Application for a non-material amendment following a grant of planning permission.

Number	36
Suffix	
Property name	
Address line 1	Surfleet Road
Address line 2	Surfleet
Address line 3	
Town/city	Spalding
Postcode	PE11 4AG

Reference number:	<input type="text" value="H17-0367-18"/>
Date of decision	<input type="text" value="18/06/2018"/>

1st floor master bedroom to be made wider

0316(20)003

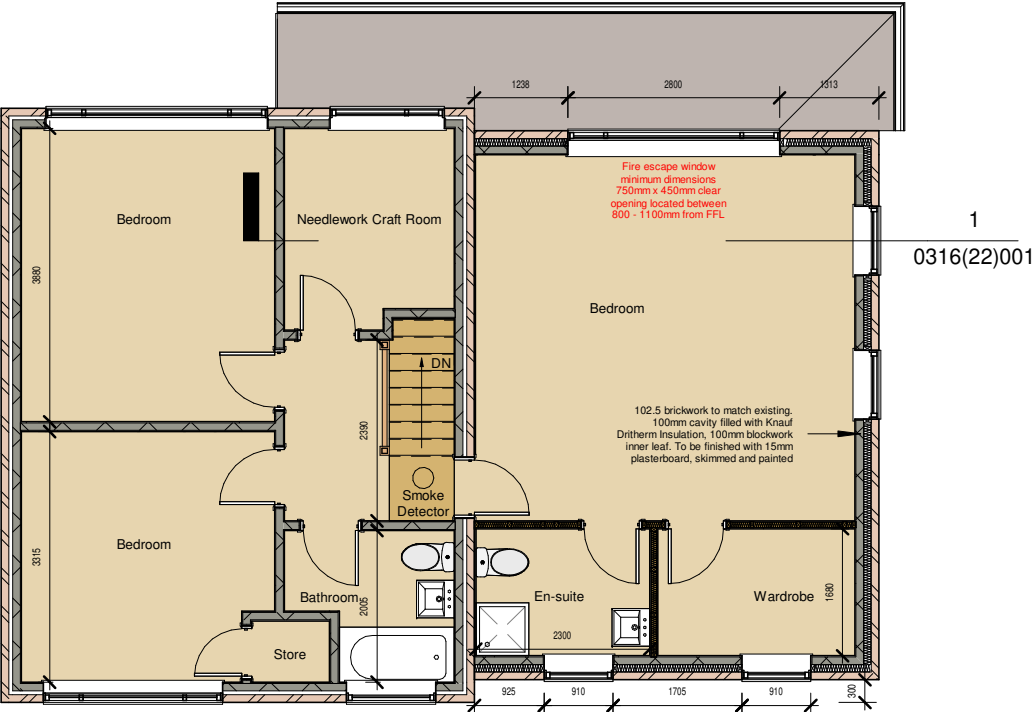
Larger bedroom / en-suite / dressing room required by applicant.
